# KITTITAS COUNTY

### MEMORANDUM

**TO:** All Staff  
**FROM:** Public Works Plan Review Team  
**DATE:** December 15, 2025  
**SUBJECT:** SPF-25-00009 Mills

MILLS-2 SHORT PLAT

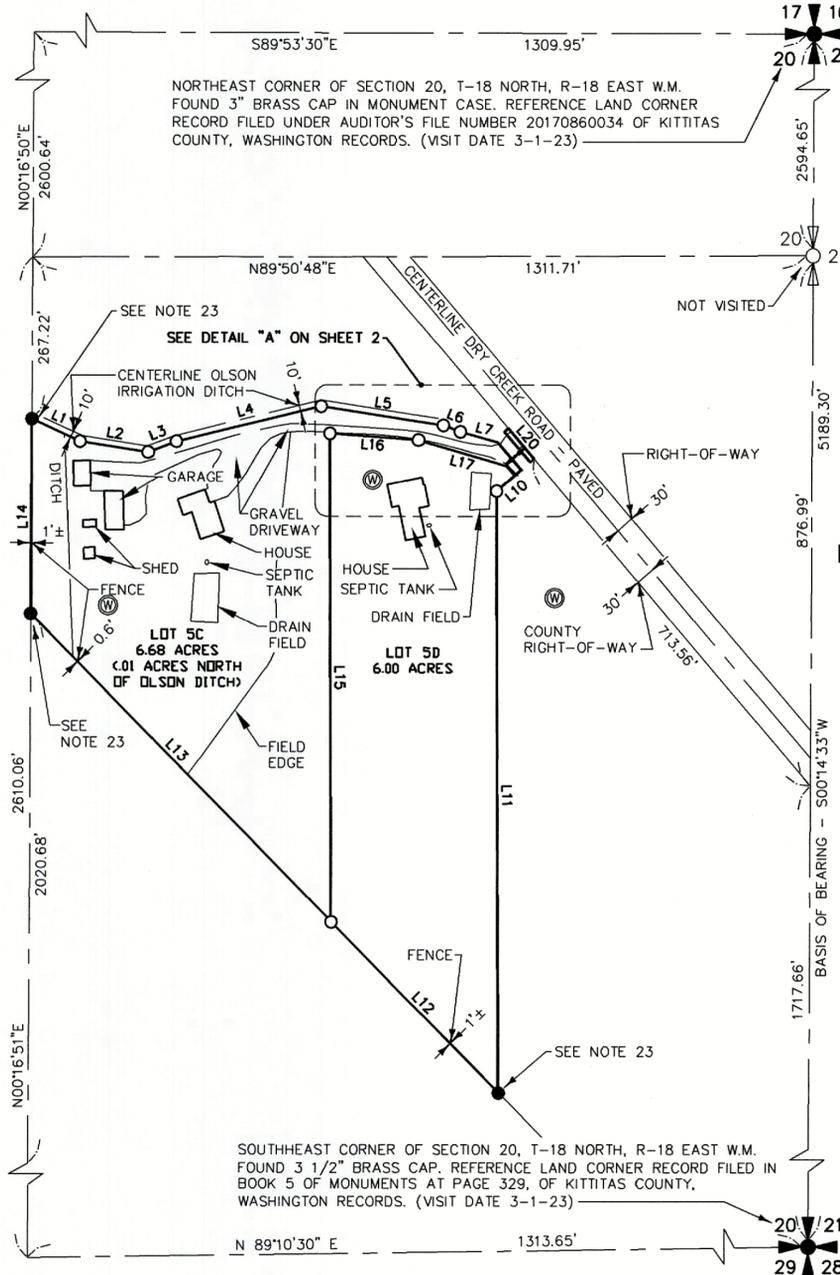
<b>ACCESS</b>	<ol style="list-style-type: none"> <li>1. An approved access permit shall be required from the Kittitas County Department of Public Works prior to creating any new driveway access or altering an existing access.</li> <li>2. KCC Title 12.04.07.060 requires a minimum 30' easement for a shared residential driveway recorded prior to final.</li> <li>3. Maintenance of driveway approaches shall be the responsibility of the owner whose property they serve. The County will not maintain accesses.</li> <li>4. Any further subdivision or lots to be served by proposed access may result in further access requirements. See Kittitas County Road Standards.</li> </ol> <p>In addition to the above-mentioned conditions, all applicable Kittitas County Road Standards apply to this proposal. Access is not guaranteed to any existing or created parcel on this application. (RC)</p>
<b>ENGINEERING</b>	Except as exempted in KCC 14.05.060, no grading or filling upon a site involving more than one hundred (100) cubic yards shall be performed without a grading permit from the County Engineer or Public Works designee (KCC 14.05.050). An application for grading in excess of five hundred (500) cubic yards shall be accompanied by an engineered grading plan (KCC 14.05.080). (CBP)

# MILLS-2 SHORT PLAT

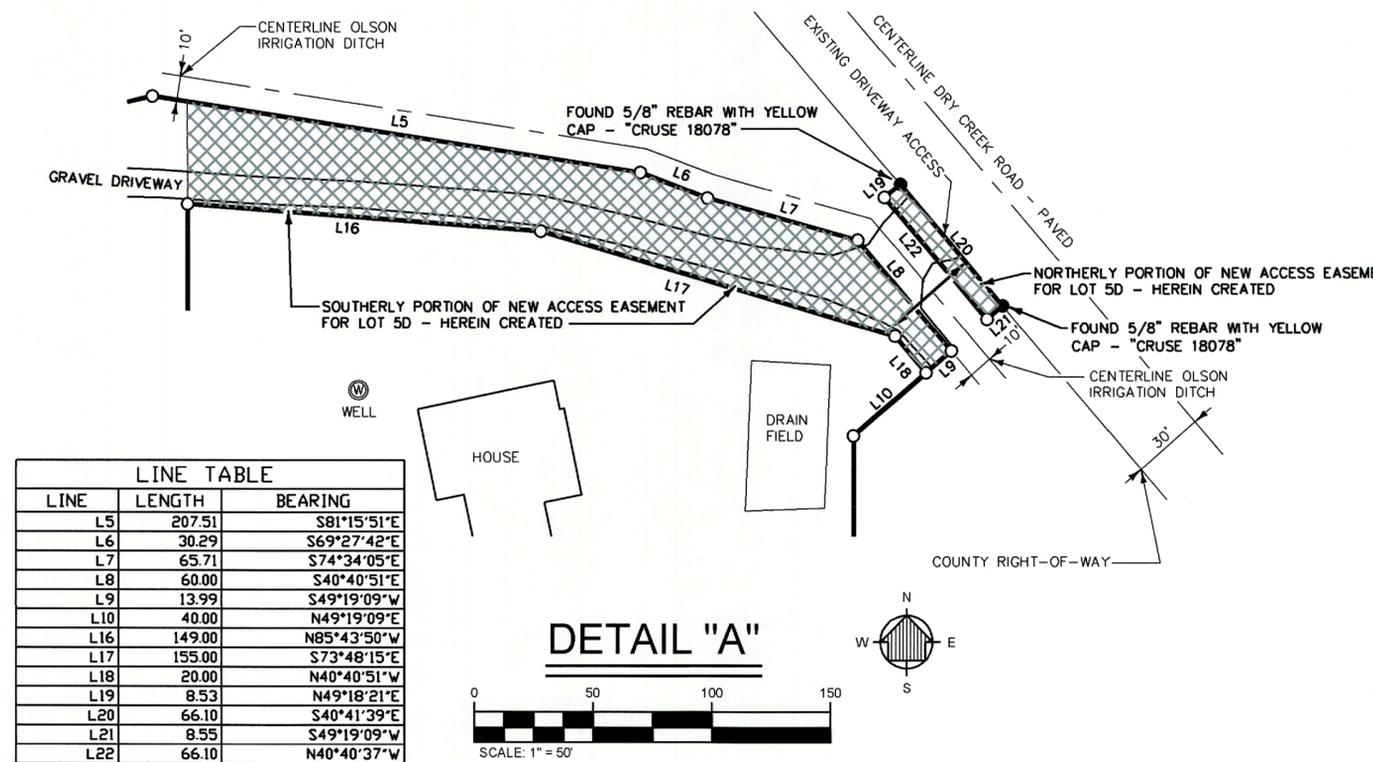
<b>SURVEY</b>	Legend needs to be added. (DF)
<b>TRANSPORTATION CONCURRENCY</b>	No transportation concurrency requirement for this project.
<b>FLOOD</b>	No comments. (SC)
<b>WATER MITIGATION/ METERING</b>	KCC 13.35.027 requirements for water mitigation and metering have been met for final plat approval. (SC)
<b>AIRPORT</b>	No Comments. (RC)
